***MODIFICATION REQUEST:  
Residential and Child Care Centre  
Development  
14-18 Boondah Road Warriewood  
MP10\_0177 MOD 12***

Director-General's  
Environmental Assessment Report  
Section 75W of the  
*Environmental Planning and Assessment Act 1979*

November 2012

THIRD FLOOR
SCALE 1:200

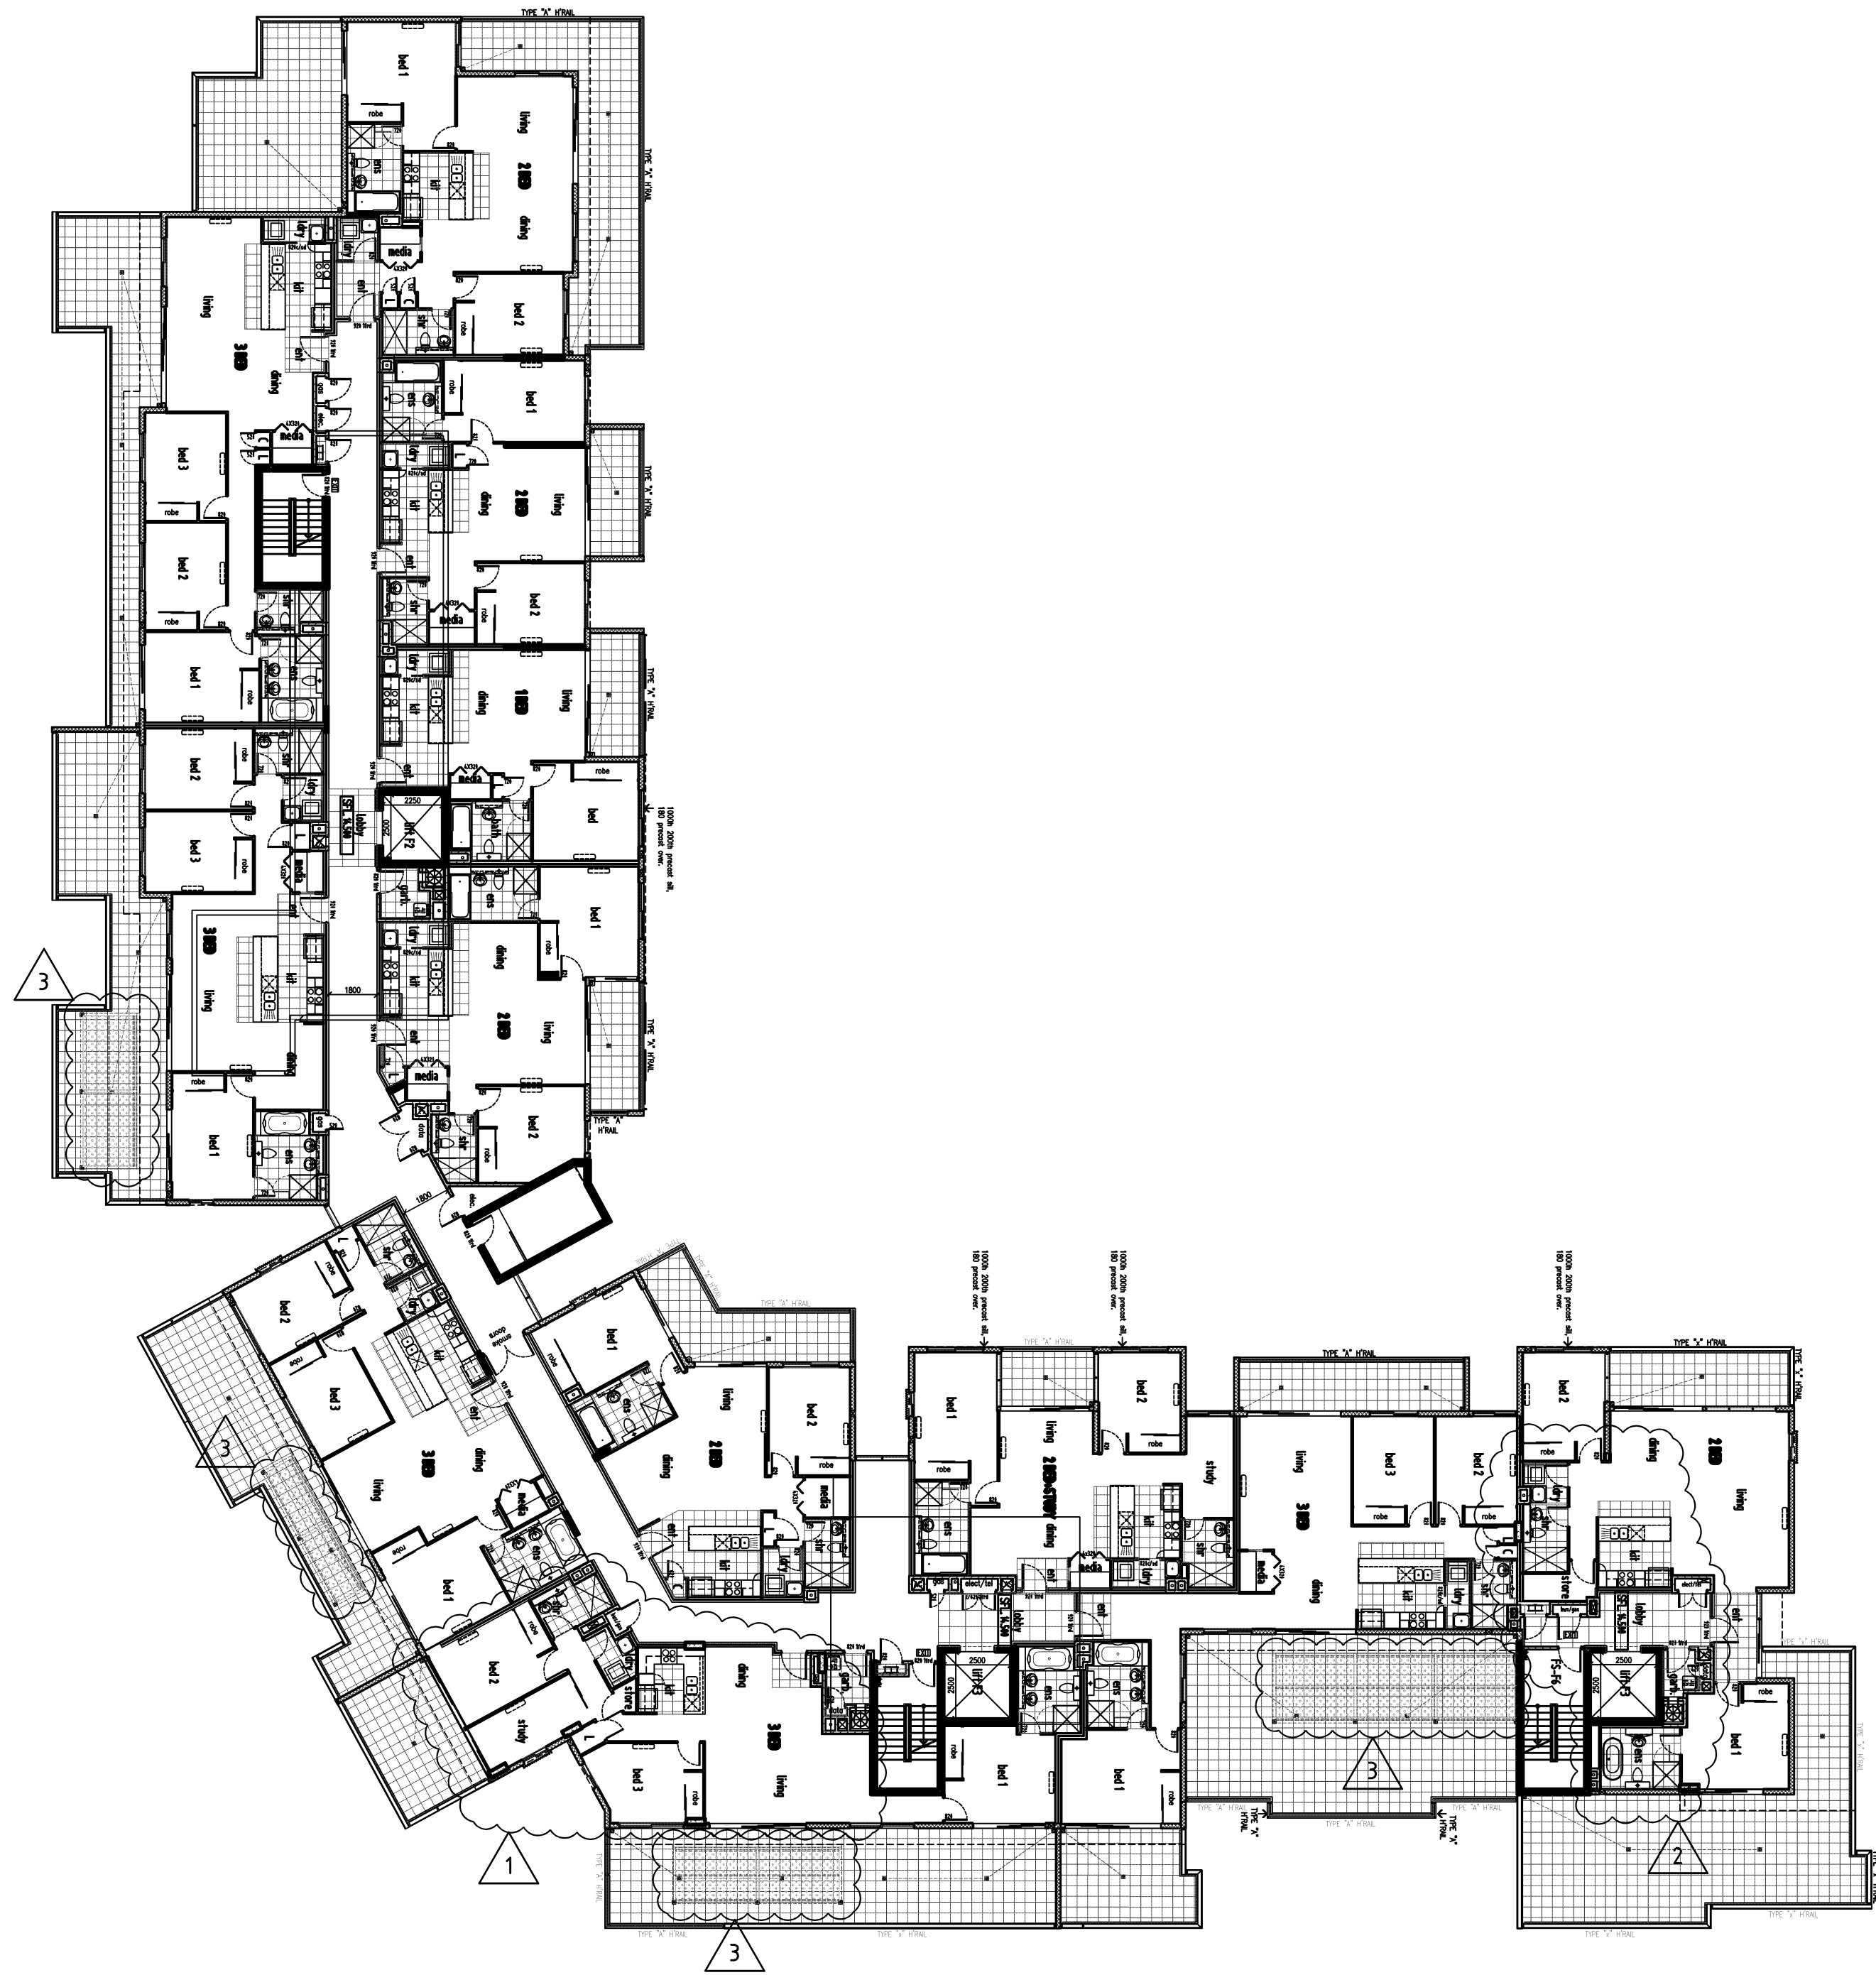
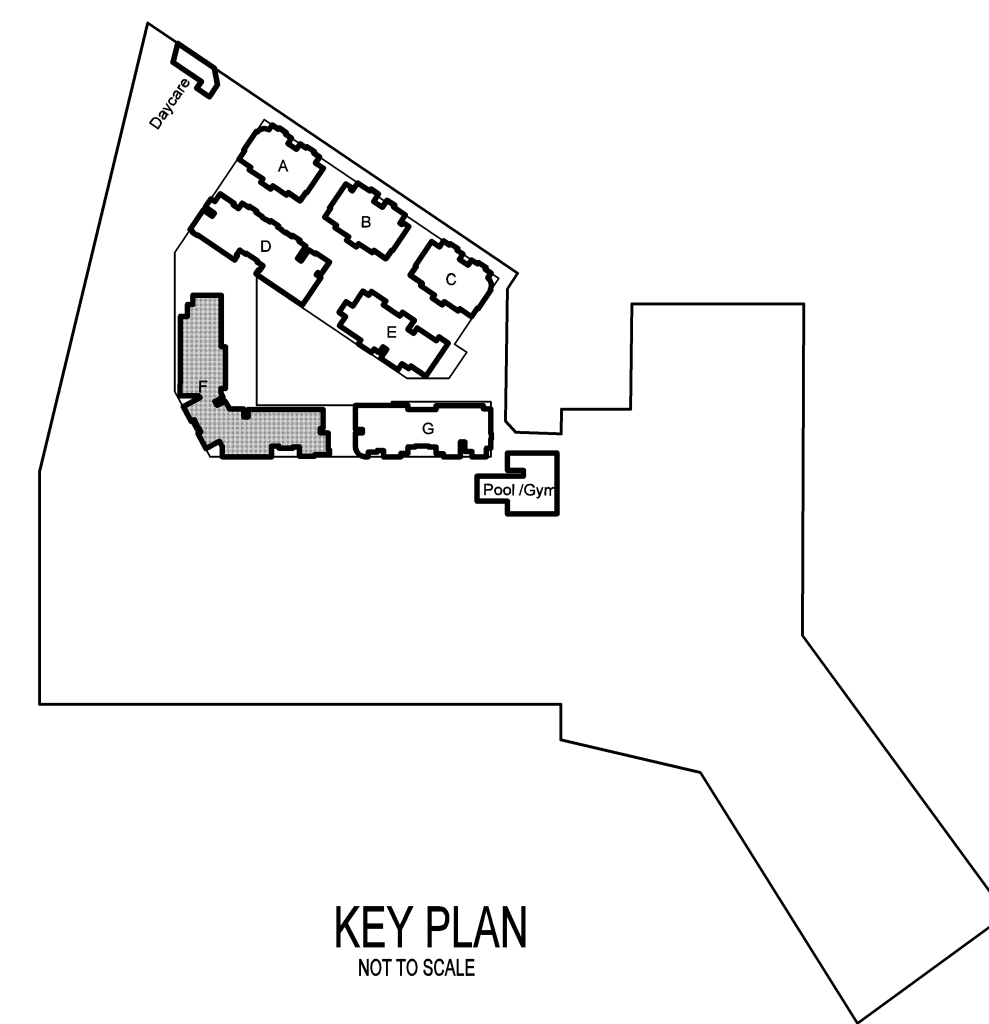
The determination of the original development required that car park spaces are to be provided in accordance Council's DCP requirements, which identifies specific rates based on the number of bedrooms contained in a unit. The internal layout of Unit 349 is modified under this application by the addition of a study. The proposed study occupies a portion of an approved bedroom, which is depicted in **Figure 5** below.

In comparing a portion of the approved and proposed floor plans of Building F, the size of the proposed study is considered to be sufficiently constrained making it undesirable for use as a bedroom. Furthermore, even if an additional bedroom was added to Unit 349, resulting in a total of 4 bedrooms, no change to the required number of car park spaces would result as no rate exists for units containing over 3 bedrooms under Council's DCP or the RMS guidelines.

FLOOR PLAN
POOL and GYM

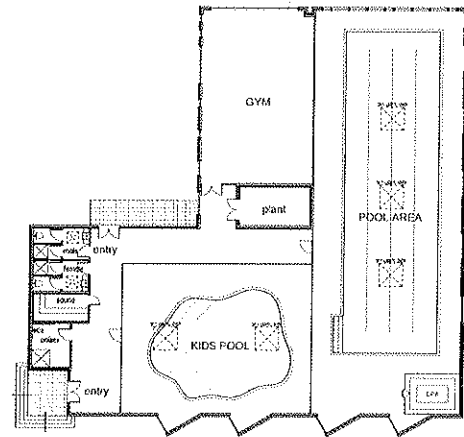
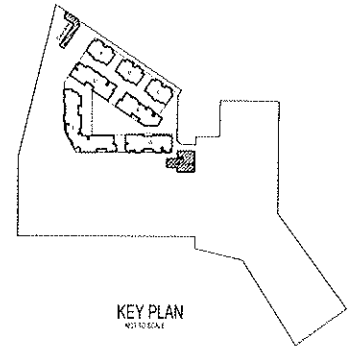
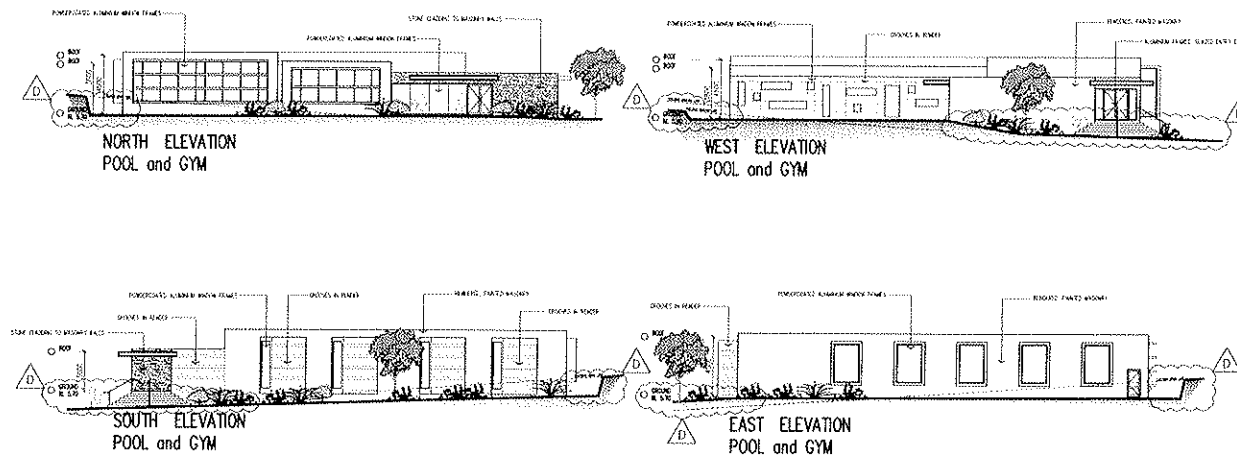
The internal design modifications proposed to Building F and the Pool Building are considered minor in scale and would maintain an acceptable level of internal amenity in accordance with the provisions of the RFDC.
